DECISION DELEGATED TO DEVELOPMENT MANAGER

Application No:	H04-0169-20	Applicant:	Tidy Rentals Ltd.
Proposal:	Residential development of up to 9 dwellings, including demolition of existing dwelling (Access, Layout and Scale to be considered).		
Location:	12 Market Place Donington Spalding		
Terminal Date:	26th June 2020

A		DRAWING GENERALLY UPDATED		31.03.20		jg		
Rev	Revision note			Date		Drawn by		
   Framework Architects		PROPOSED RESIDENTIAL DEVELOPMENT LAND BEHIND 12 MARKET PLACE DONINGTON						
		Drawn by DK		Checked		Date FEB 20	Scale 1:500 at A2	
		PROPOSED SITE PLAN			Dwg No J1930 00104		Rev A

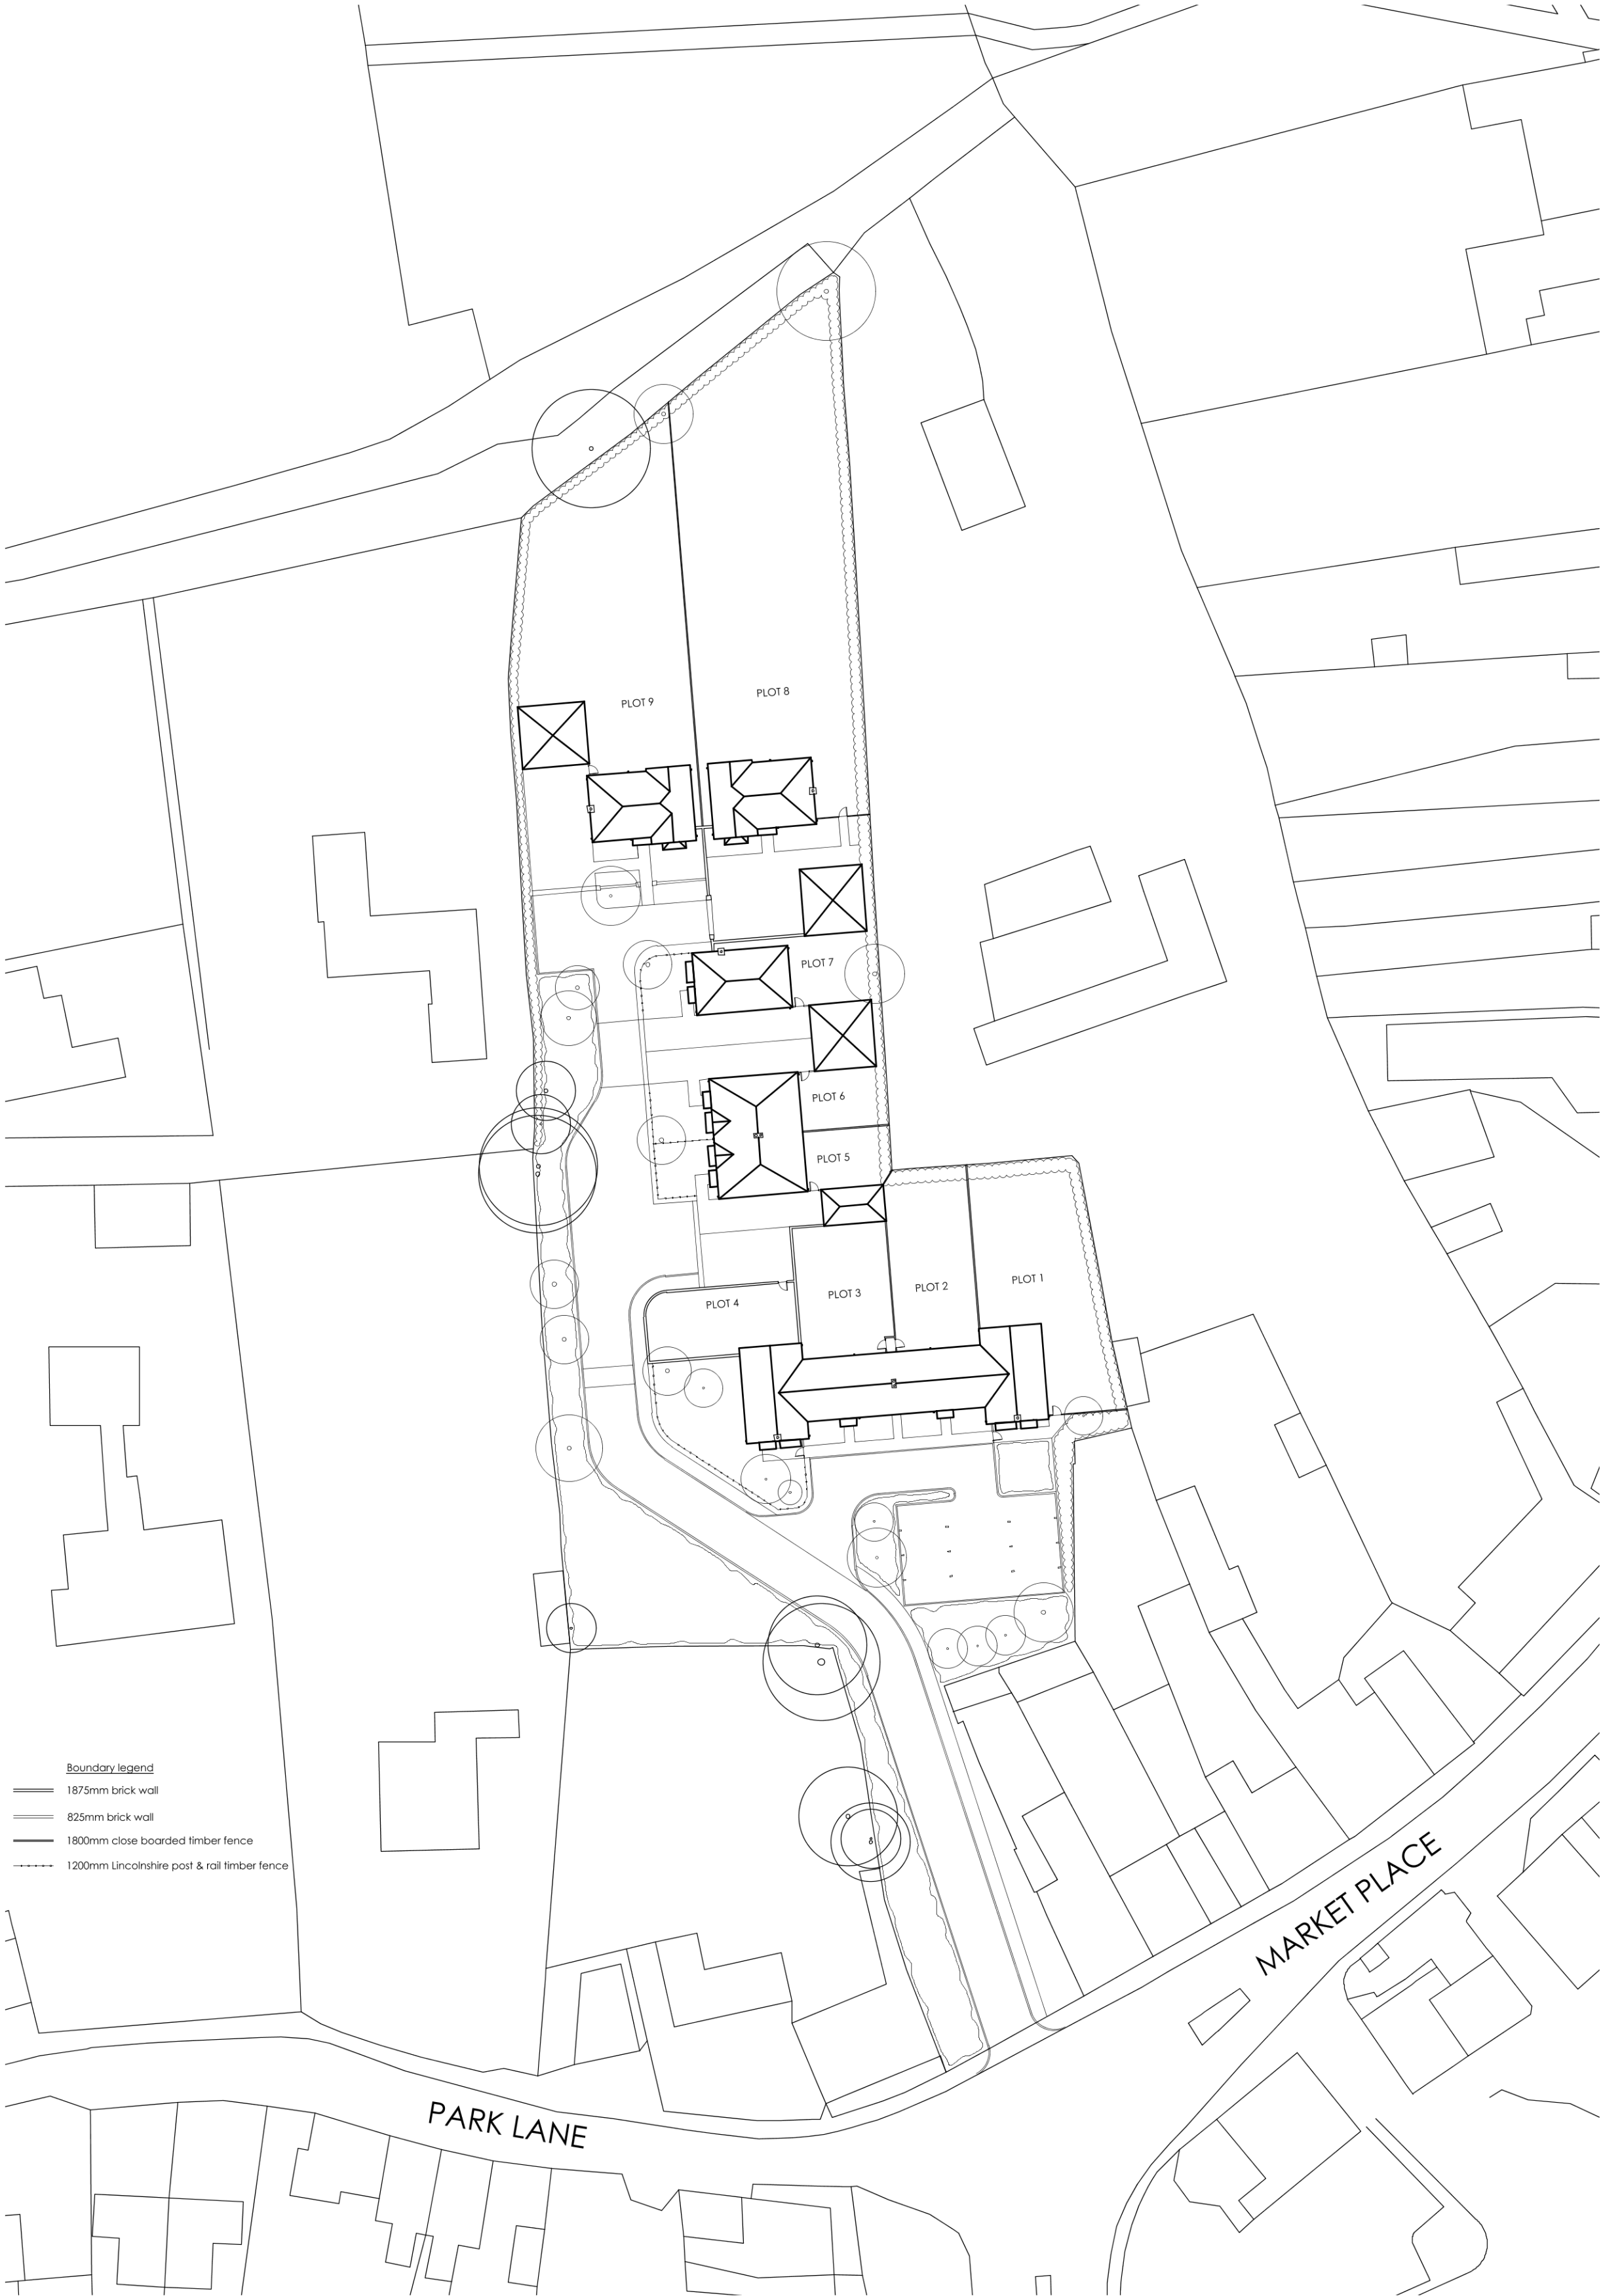
IN CONCLUSION: Ideally the proposed southernmost building to be moved slightly to the west to avoid the Root Protection Area (as described in British Standard 5837:2012) of the sycamore tree which would be covered with Conservation area status.

- This increase in number of properties has been made at the expense of providing garaging to 6 of the properties- thereby making a car park in full view of the entrance into a Conservation area.

It is considered that the development of 9 properties on a site of this size and setting constitutes overdevelopment, which is a site to the rear of St Heliers which is a locally prominent listed building and would harm the setting of not only St Heliers (in addition to the similarly Grade II Listed Nos 14 and 18 Market Place and No. 2 Church Street), but also the Grade I Listed Church of St Mary & Holy Rood which is easily visible from within the proposal site.

Given the form and layout proposed, it is considered that dwellings proposed on plots 6, 7 and 9 could give rise to overlooking and the perception of overlooking to Parkwood, Park Lane at a distance that would significantly impact on the amenity of that property.

In addition, the orientation of Plot 4 could give rise to overlooking and the perception of overlooking to the rear and garden of St Heliers, albeit at a distance.
